Application Ref: 3/2021/0796

DELEGATED ITEM FILE REPORT: NH 26/08/2021

NON MATERIAL AMENDMENT

Application Description: Request for non-material amendment to planning consent 3/2017/0710 to allow the installation of two Velux roof windows to bedroom 2.

North East Elevation

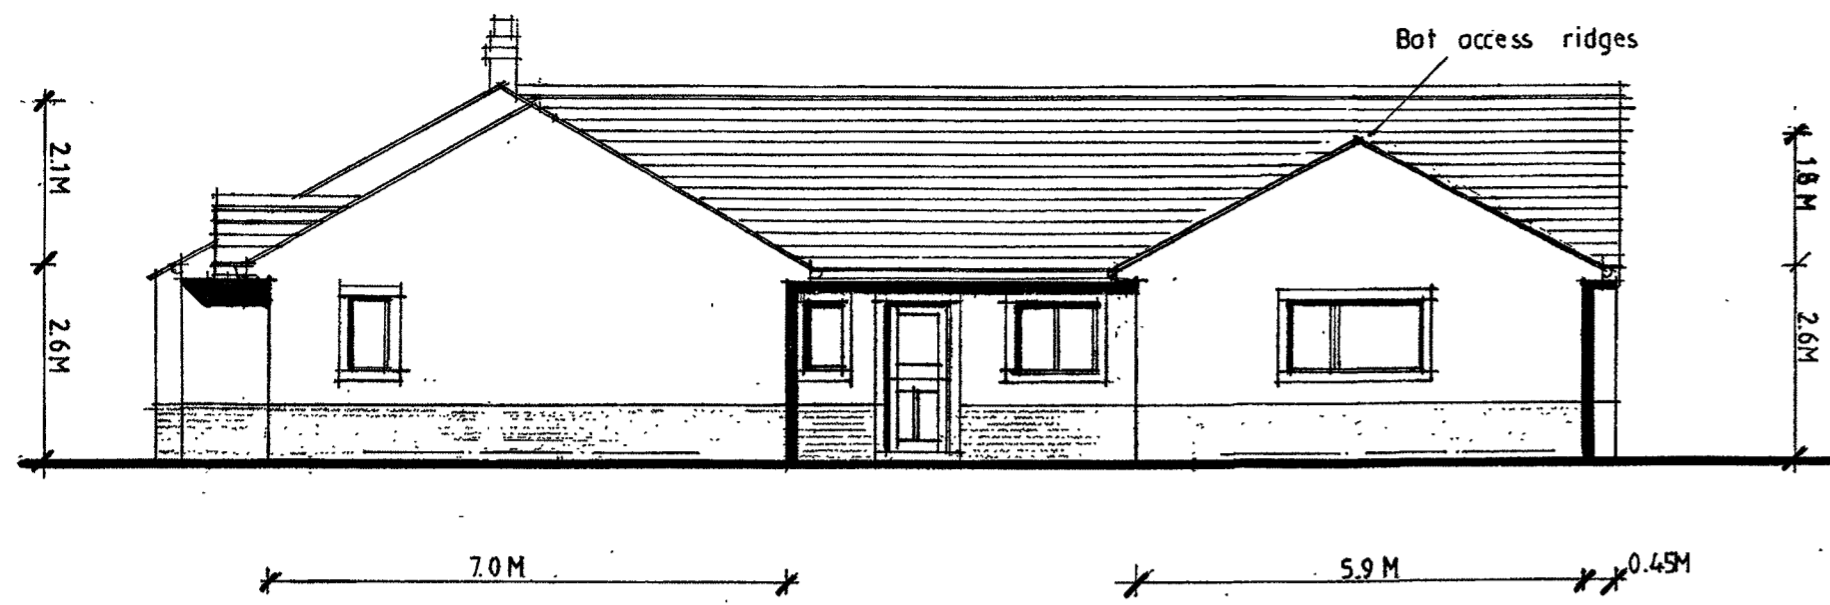
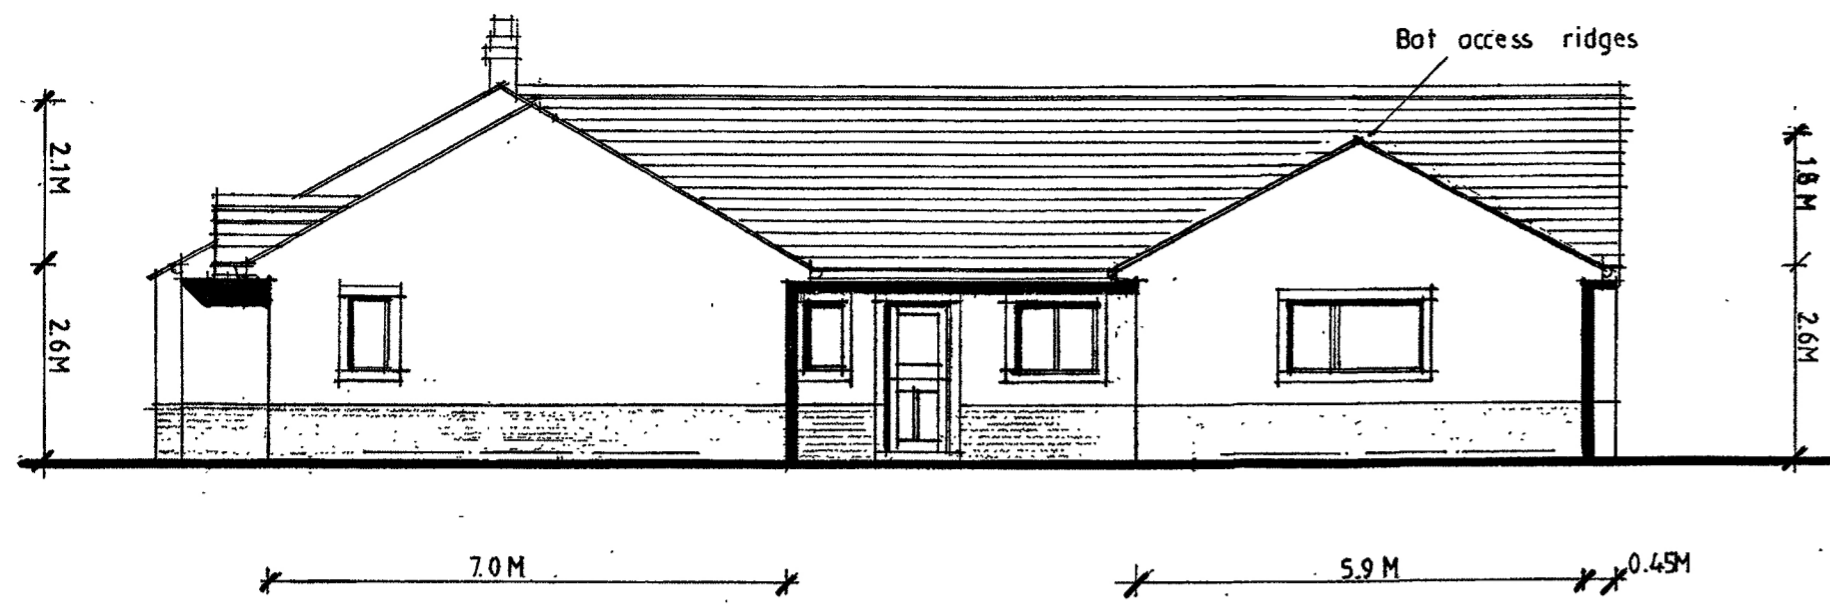
The amendment sought relates to the proposed installation of two Velux roof lights to a recently approved single storey extension to the North-eastern side elevation of the main property. The applicant also wishes to remove a window from the North-eastern elevation of the approved extension in order to provide a greater level of privacy from the neighbouring property known as Far Lathe which is located approximately 15 metres away to the North-east.

North West Elevation

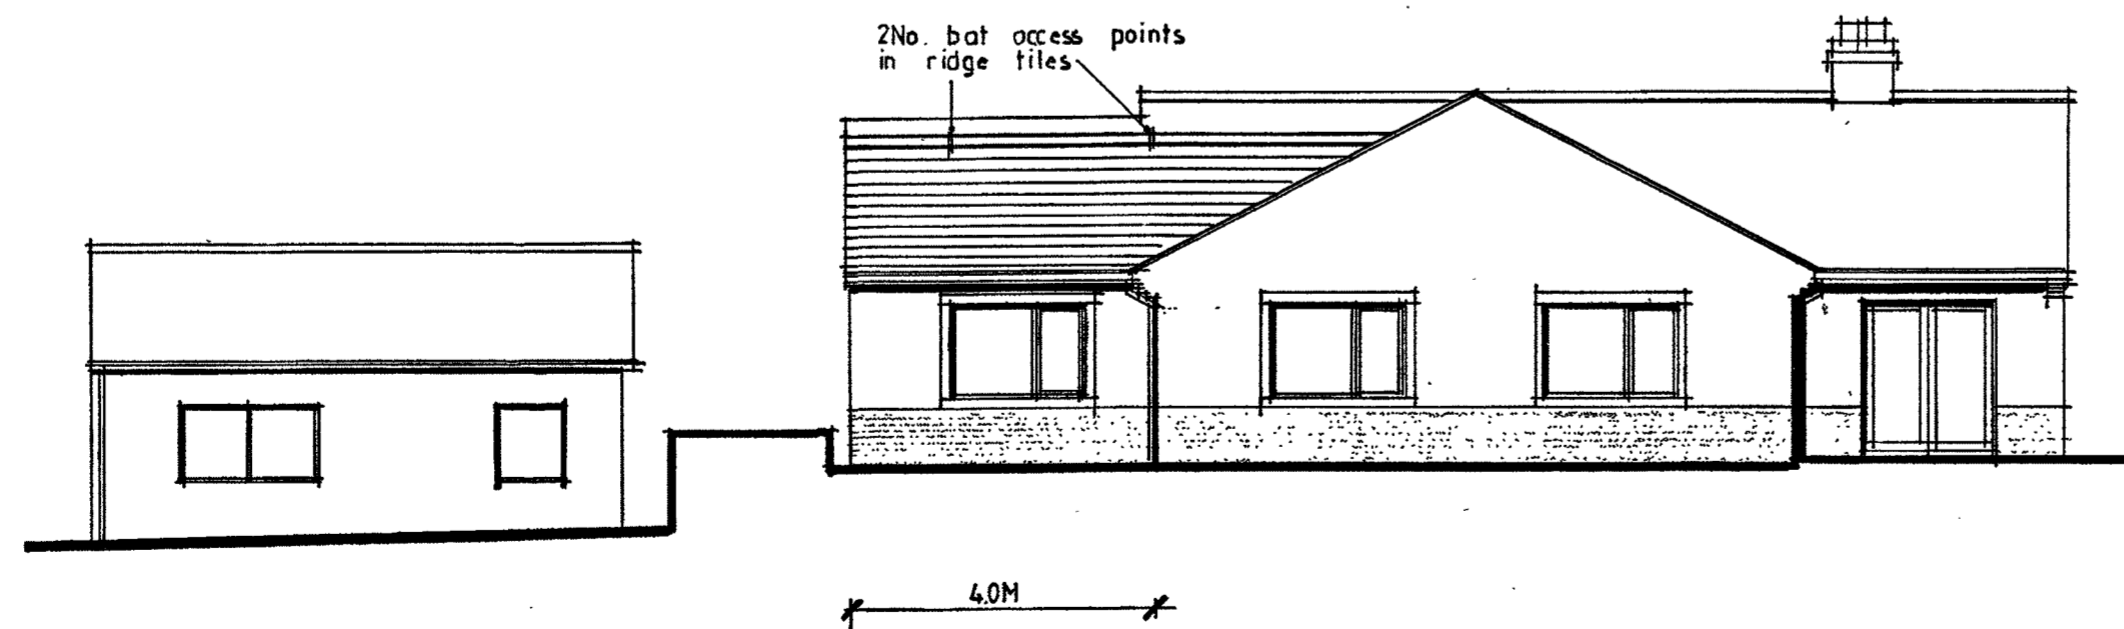
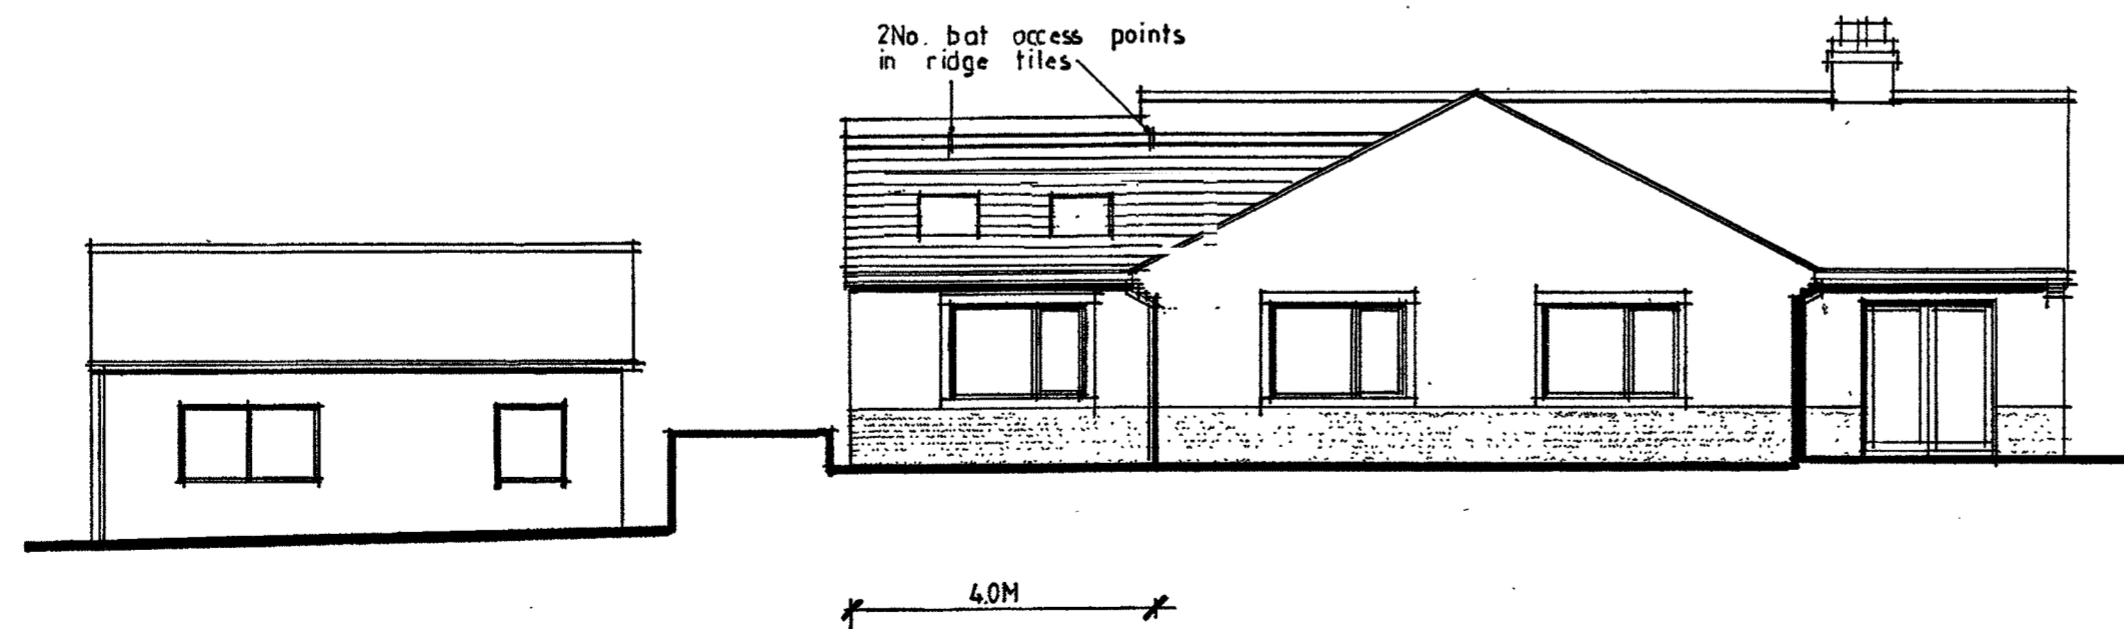
Accordingly, the applicant seeks consent for the installation of two Velux roof lights to the North-western roof slope of the approved bedroom extension in order to compensate for the loss of natural light that would occur from the loss of the removed window.

The proposed roof lights would be angled upwards from the North-western roof slope of the approved extension which faces towards open fields therefore it is not considered that the proposed amendments would allow any new opportunities for overlooking into the adjacent neighbouring property.

The proposed roof lights would have a negligible visual impact in as much that they would be sited to the rear of an isolated rural property where the roof lights would only be partially visible from the curtilage of the neighbouring property's garden.

The roof lights would have a minimal outward projection from the roof and would each measure 1.1 x 0.7 metres therefore the proposed amendments would be a modest addition to the approved extension. Accordingly, it is not considered that the proposed amendments would result in a fundamental change in the design or external appearance of the extension.
